Application number: 2025/92206	
What is the application for?:	Demolition of existing dwelling and erection of five dwellings with associated e
Address of the site or building:	42, Robin Royd Lane, Mirfield, WF14 0LG
Postcode:

Type of comment: An objection	
Do you wish your comments to be published on the website anonymously?	<input type="checkbox"/> Yes
<p>As a resident of Robin Royd Lane, where I have lived for 5.5 years I write to formally object to the above planning application.</p> <p>I support the redevelopment of the land, but the proposed plans are completely unacceptable due to its scale, design, and layout.</p> <p>These aspects would significantly harm the character of the area, the amenity of neighbouring properties, and highway safety.</p> <p>My objection is based on material planning considerations, with particular reference to the National Planning Policy Framework (NPPF) and the Kirklees Local Plan, especially Policies LP24, LP21, and LP30.</p> <p>The proposed building is entirely out of keeping with the established character of Robin Royd Lane.</p> <p>The height of the development and the proposed 3 stories is not in keeping with anything on the current road.,</p>

Job No: 3115
 Drawing No: 004

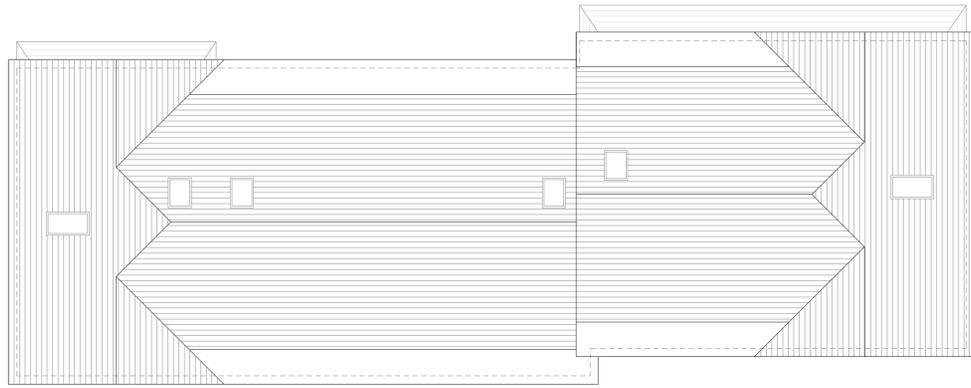
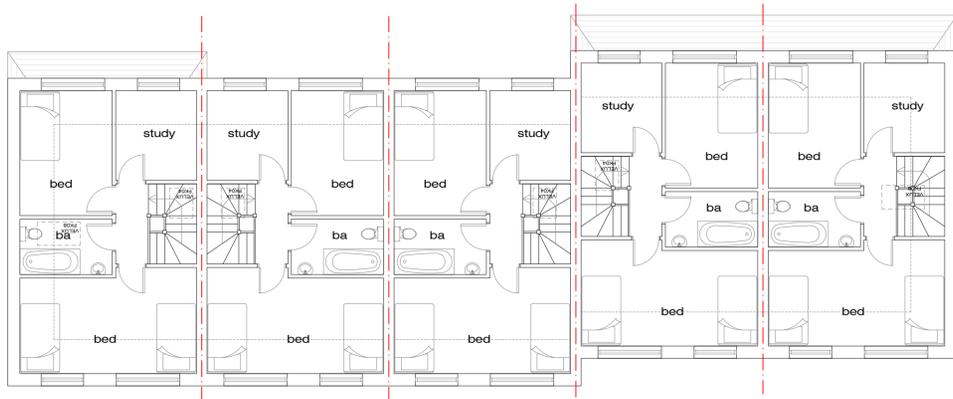
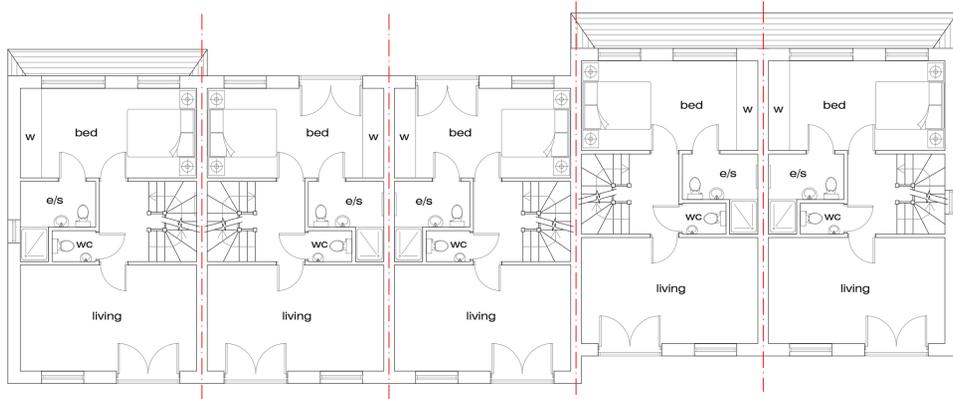
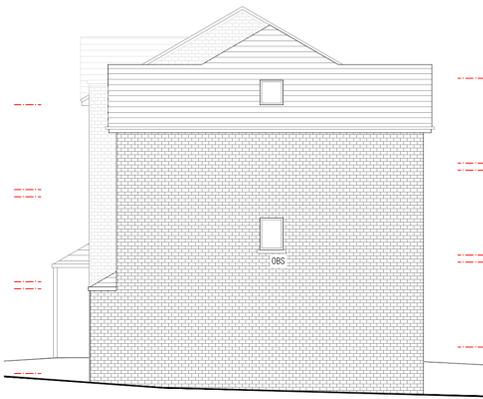
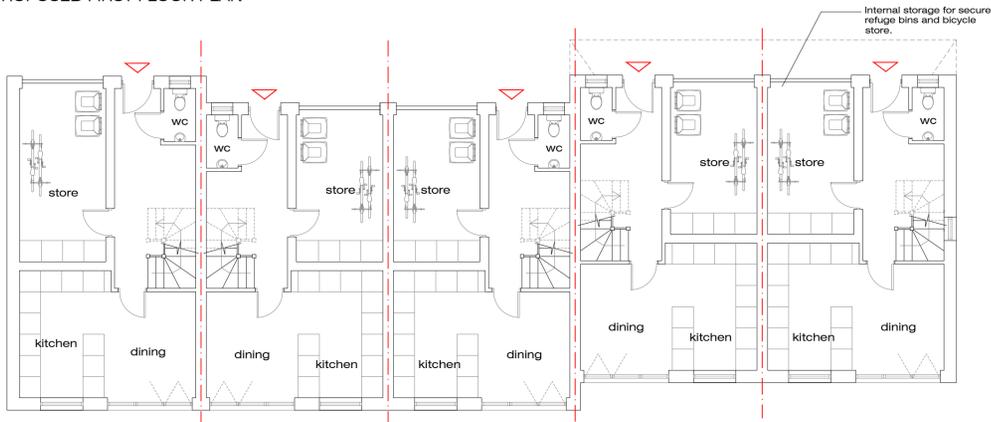
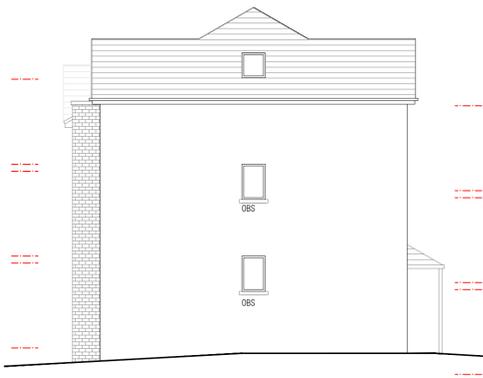
The proposed units are described as three-bedroom homes, but each unit includes two large double/twin rooms and a single room. Therefore at least a family of 5 could live here.

Each unit also includes a separate study, which could easily be repurposed as an additional bedroom. Also the proposed store area could be used on development or additional planning turning this into another double bedroom.

If the loss of internal storage space would likely lead to refuse and recycling bins being stored permanently at the front of the properties, resulting in visual harm to the street scene

The parking and access layout is impractical and unsafe. There is also no planned visitor parking.

I'm strongly of the opinion that the one floor should be removed lowering the height of the properties and making them true 3 bed properties.

I also believe and as discussed the block format should become two sets of semi detached properties to enabled more parking down the side of each property and not stack parking as planned

With the current stack parking means the proposed planed pushed the properties further backwards, therefore clearly blocking neighbours views and the development becoming oversized and unsightly.

The three central properties have no direct front access, forcing movement via garden gates onto an unadopted road, which I believe is privately owned.
